Online Comment

Application H11-0508-20
Location Rear of 15, 17 & 19 Market Street Long Sutton Spalding PE12 9DD
Proposal Proposed residential development comprising 4 dwellings

Name Ian Marshman - Historic Environment Officer
Address Historic Environment Officer Lincolnshire County Council Lancaster House LN1 1XX

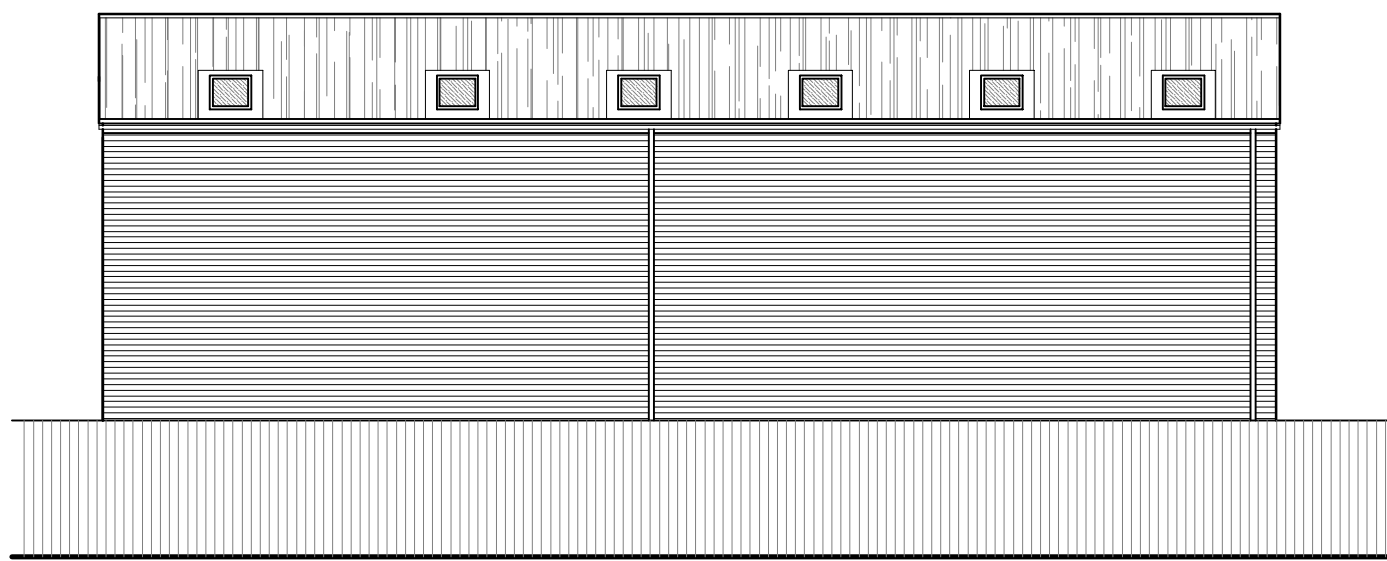
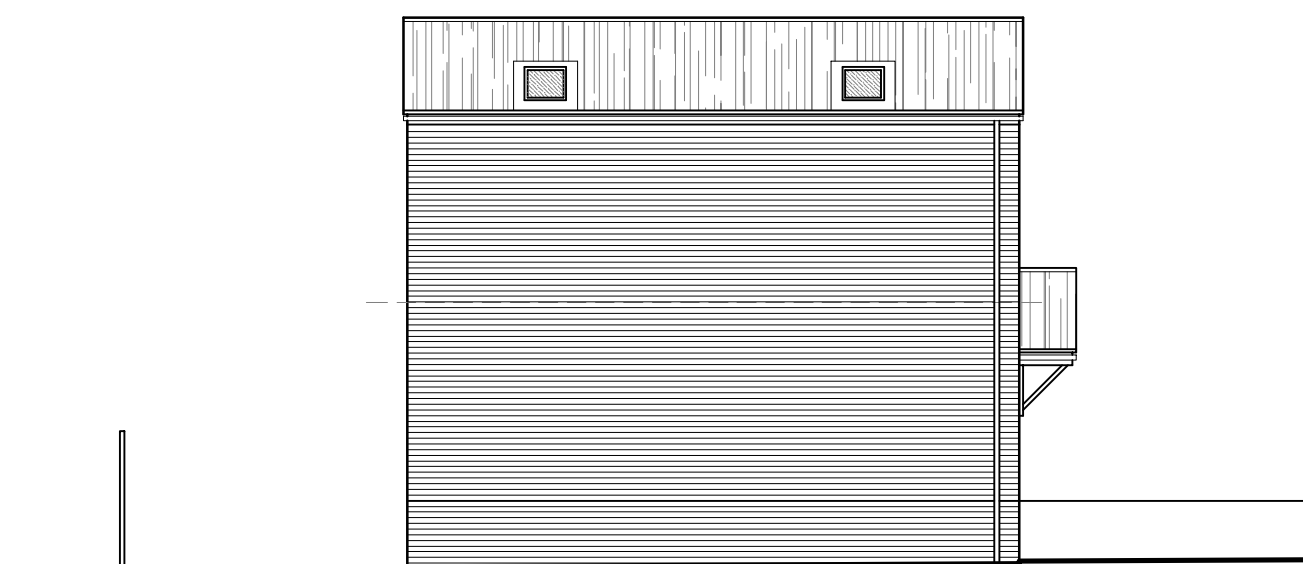
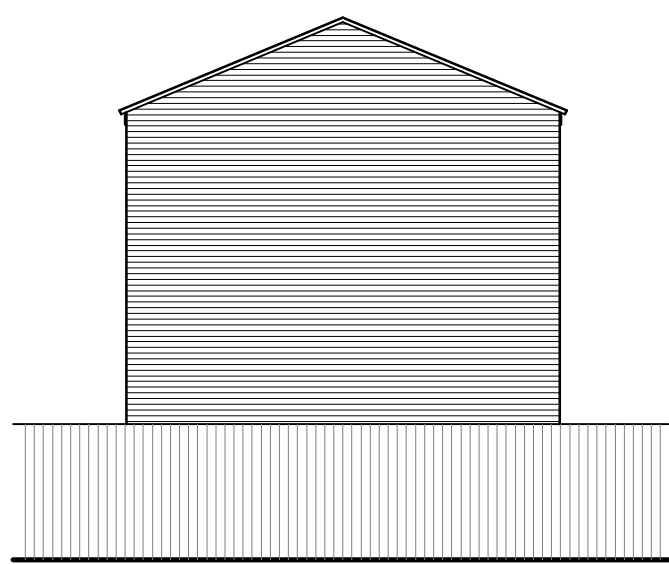
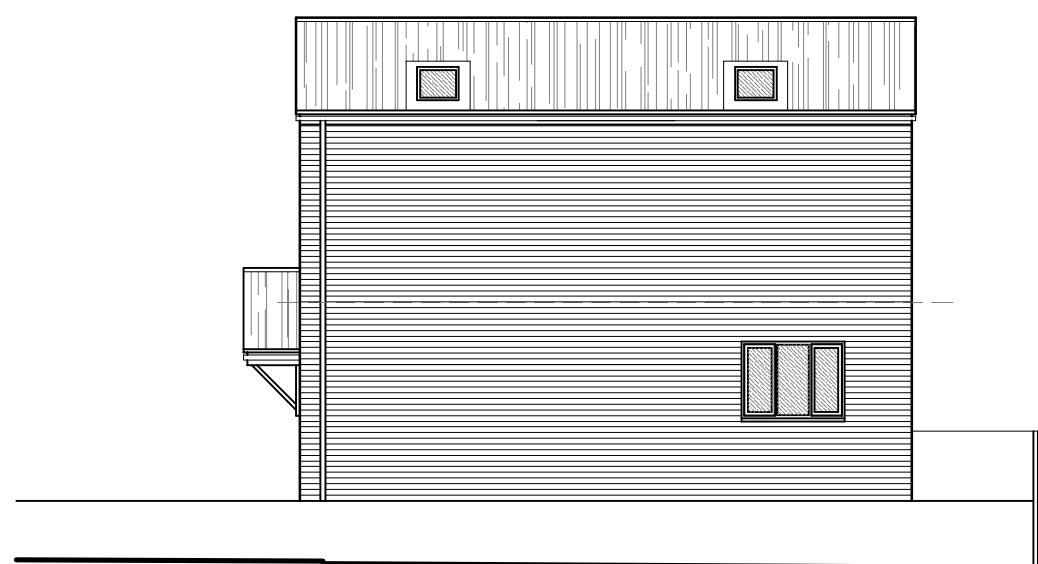
No justification has been provided for why the present application proposes a new design from that previously approved, which was agreed with the conservation officer in order to reflect and respond to the timber warehouse that permission was granted to demolish, in light of its poor structural condition. It is not clear how the revised design relates to the special architectural and historic interest of the surrounding conservation area in its choice of form, detailing or materials. With windows and doors of UPVC in modern forms, and domestic gabled porches and Juliette balconies giving the appearance of a modern terrace rather than a converted historic warehouse.

Having carried out a site visit it is clear that the proposed building would be prominent in views of the Grade II Listed 21 Market Street next door and the locally listed (but non-designated) 15-17 Market Street within whose curtilage this development is situated, as well as from Bull Lane. The previously approved plans included a lower detached building on the Bull Lane side, but the current proposals would appear to stand much taller than the locally listed 19th century terraced housing at 2-6 Bull Lane, particularly when combined with the difference in ground level.
